STATUTORY PLANNING CONSULTATION RESPONSE

Application Number:	3/2025/0801
Proposal:	Proposed erection of new residential development comprising 80 new homes, including 30% affordable housing, open space and associated infrastructure.
Location:	Land to east of Salesbury View Wilpshire

Objection 01 – Inadequate Surface Water Sustainable Drainage Strategy

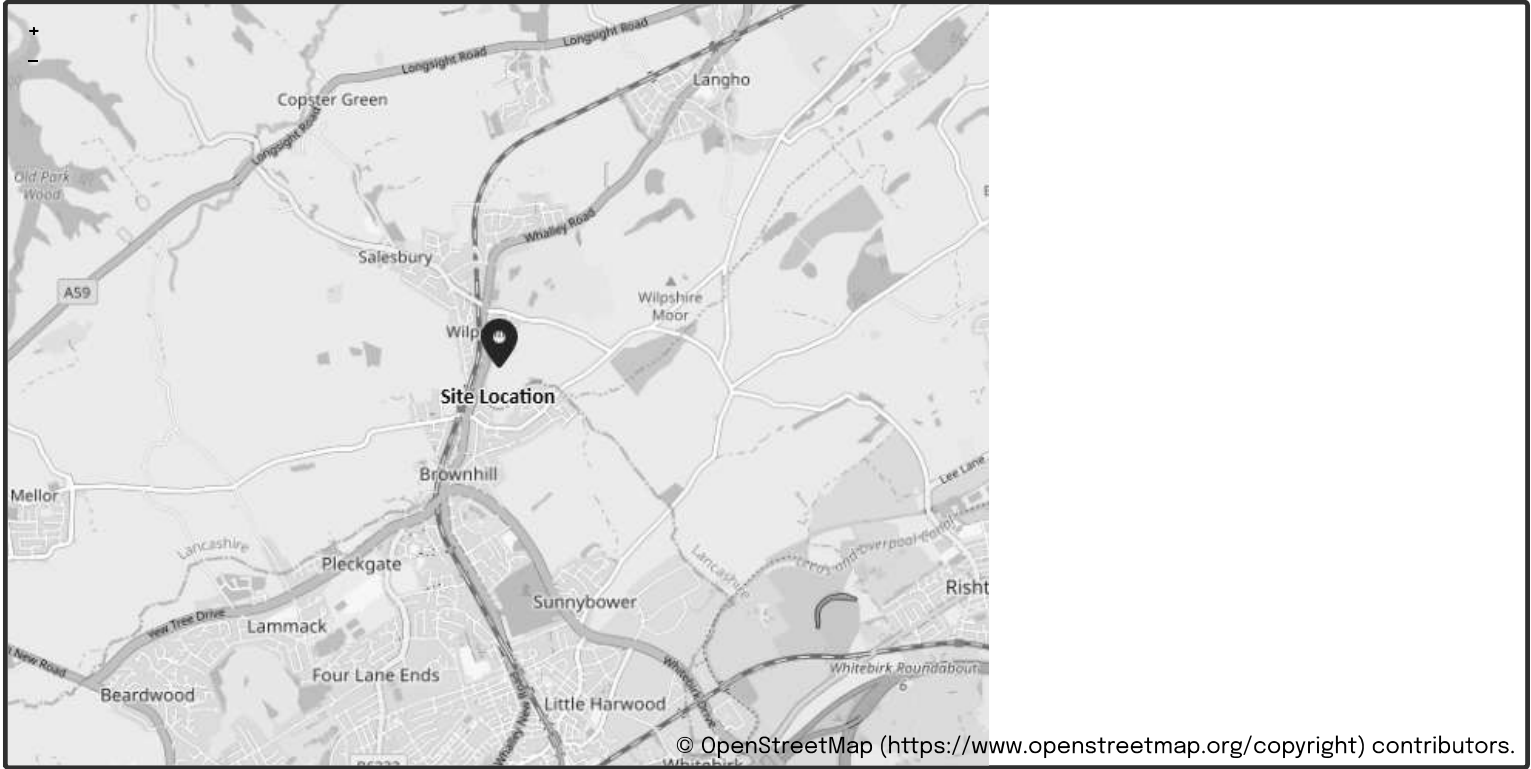
3. **Inconsistent contributing area to size the SuDS** – The proposed drainage strategy fails to demonstrate compliance with Standard 3 of the National Standards for Sustainable Drainage Systems.

The submitted drainage strategy sizes the SuDS and the discharge rate 14.98l/s based approximately on a contributing area of 1.722ha only, however the applicant has provided evidence that the proposed contributing area for the development is approximately 1.988ha, in addition to this the applicant has failed to include the proposed attenuation pond as part of the contributing area, and therefore means that the SuDS is potentially undersized.

Standard 3 requires that the entire development area that could potentially drain to the proposed surface water drainage system in an extreme event shall be used for estimating greenfield runoff rates and volumes (including both permeable and impermeable surfaces). For the avoidance of doubt, the runoff area used in any of the runoff estimation methods should be consistent, as outlined in The SuDS Manual.

Drawing Title:
**SCHEMATIC DRAINAGE
LAYOUT
SHEET 2**

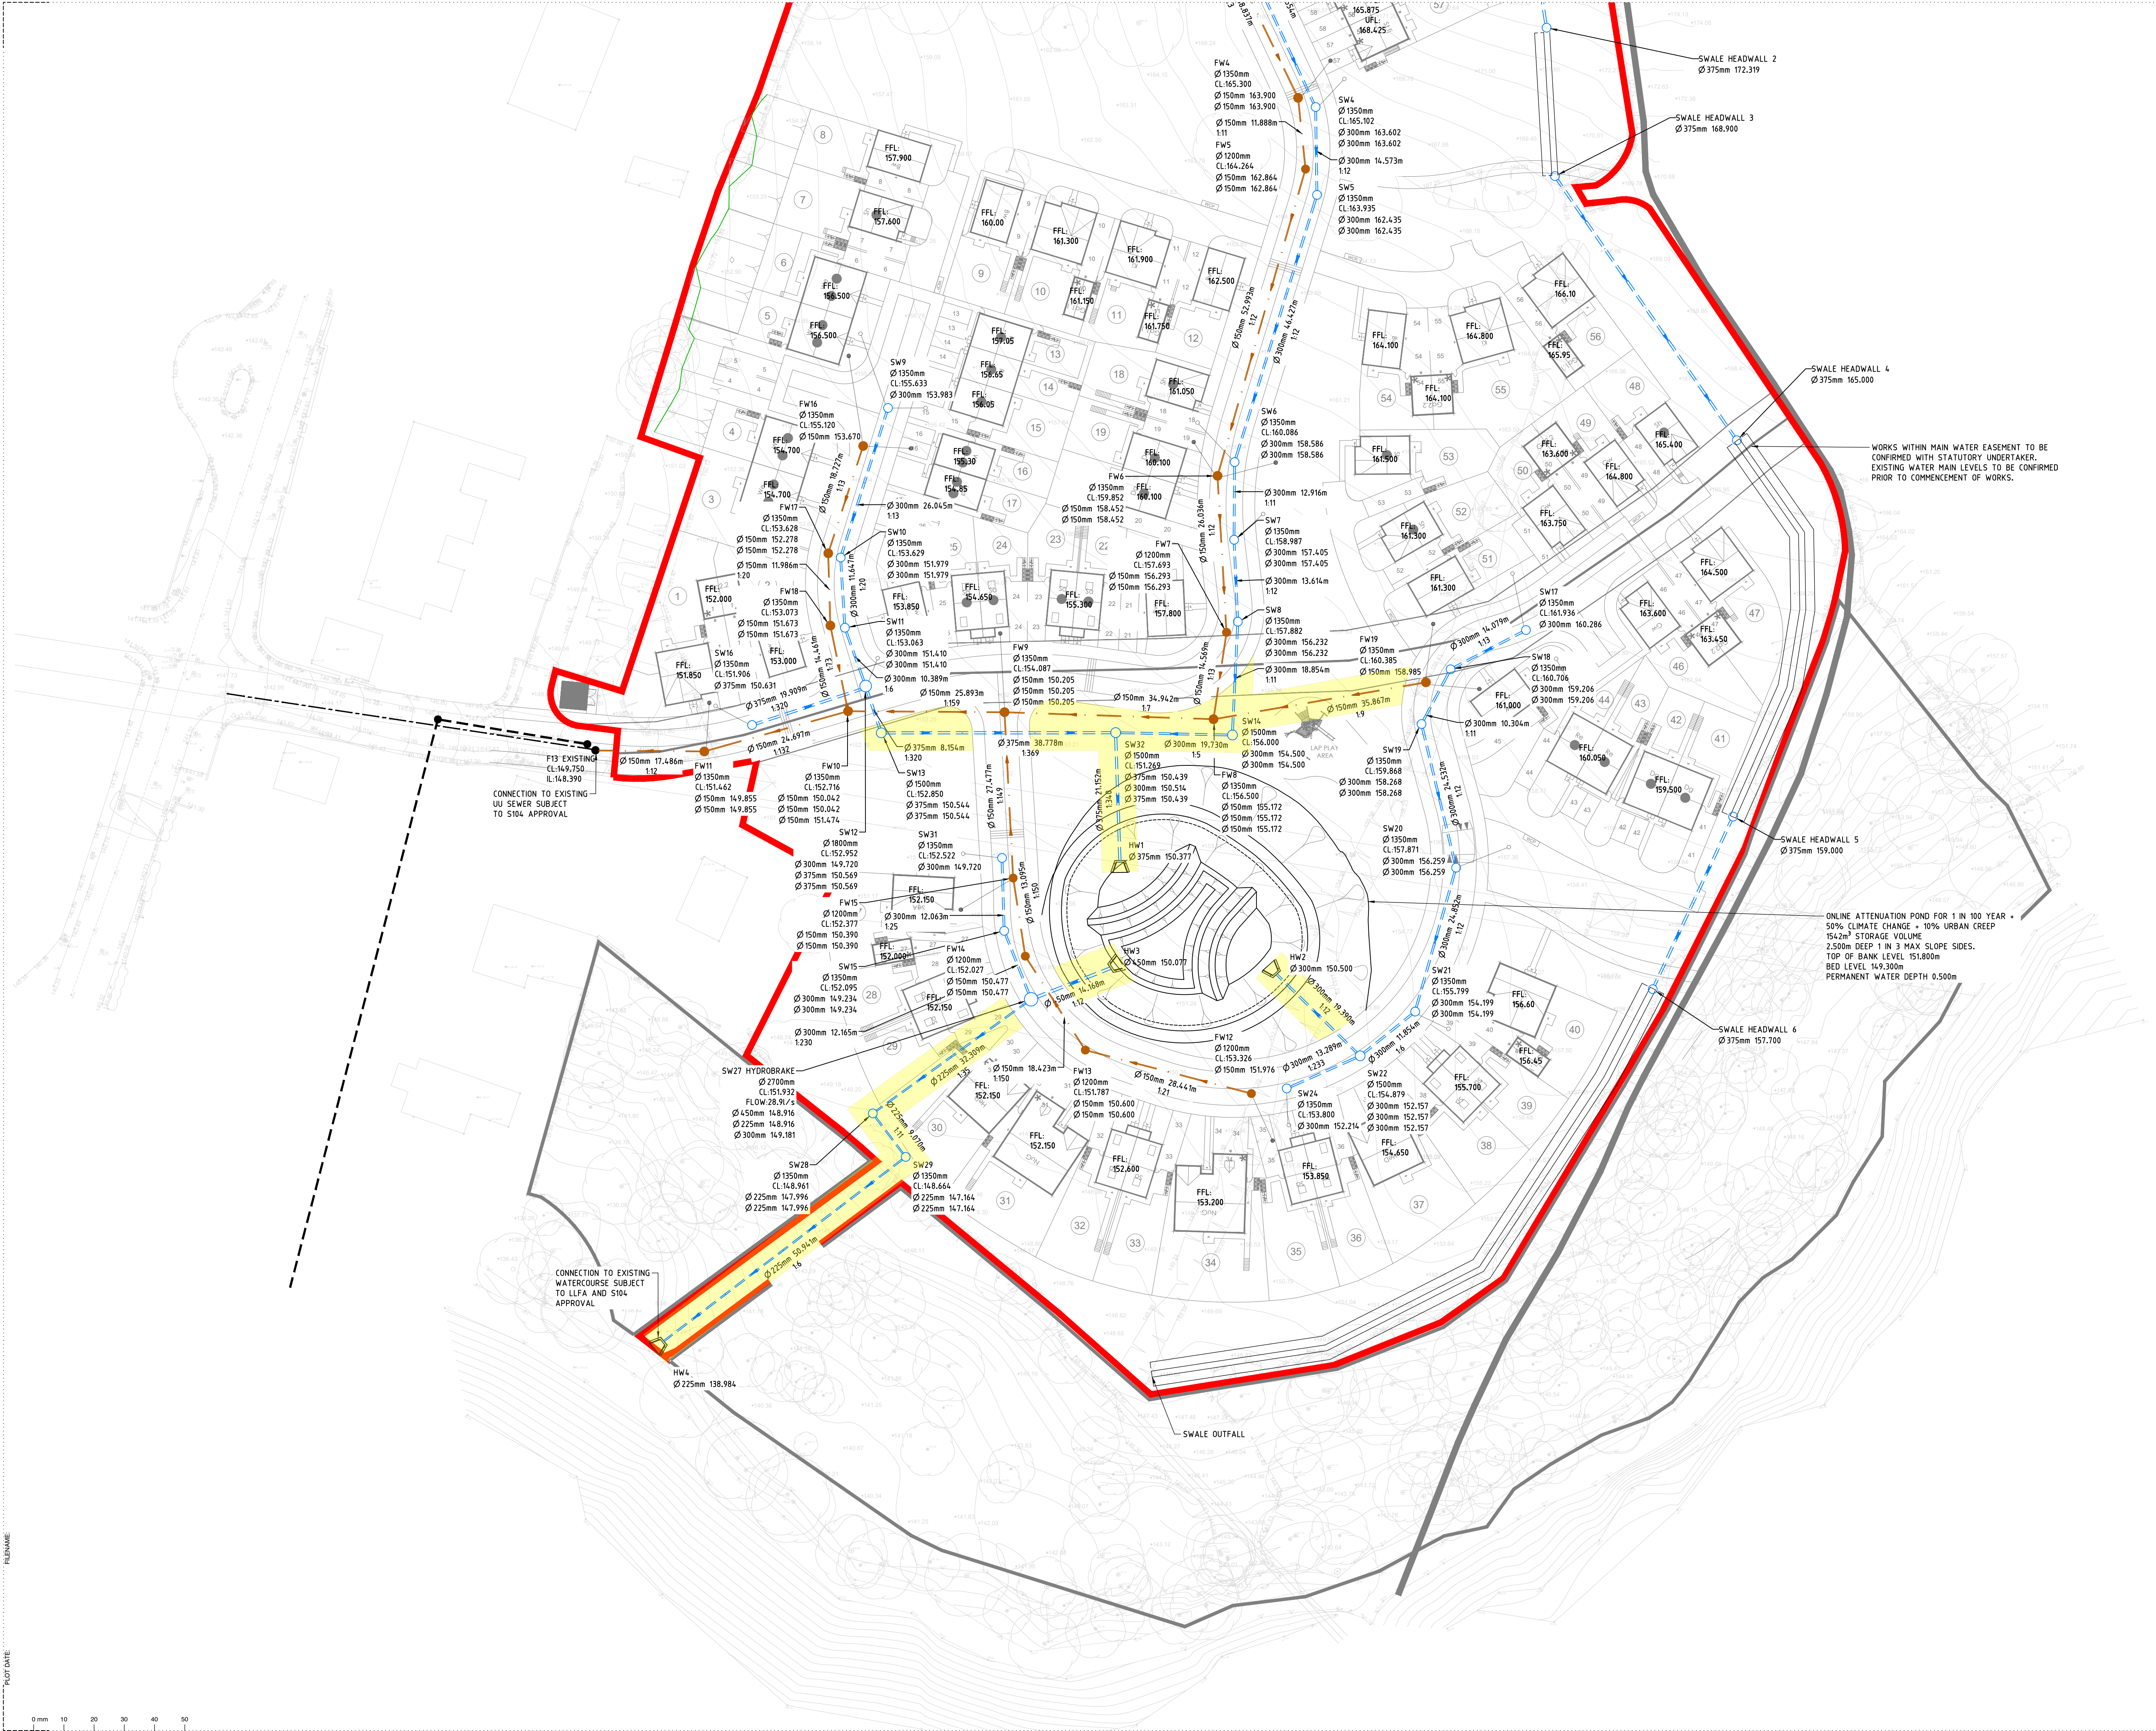
1. **Inadequate Runoff Destination** – The proposed drainage strategy fails to demonstrate compliance with the priority hierarchy of runoff destinations set out in Standard 1 (Runoff Destinations) of the National Standards for Sustainable Drainage Systems. This Standard requires applicants to demonstrate that surface water runoff from new developments will be discharged according to a priority hierarchy, and for all higher priority destinations to be utilised to the maximum extent practicable.

In this case, the applicant proposes to discharge surface water runoff from this development to the watercourse to the south. However, sufficient evidence has not

been provided to demonstrate that all higher priority final destinations have been utilised to the maximum extent practicable. This includes non-potable use and infiltration as specified and detailed within Standard 1.

The applicant has stated that infiltration is not possible on the proposed development and, therefore, while these areas, such as gardens, roadside verges and areas of public open space, may not be positively drained, they may contribute indirectly to the drainage system during extreme events.

The applicant must design their SuDS with an appropriate estimation of the area contributing to the drainage system, both permeable and impermeable, with evidence of this area provided through an appropriate contributing area plan, or

otherwise demonstrate how surface water runoff from non-drained areas will be managed without contributing to the drainage system and without increasing flood risk onsite or elsewhere.
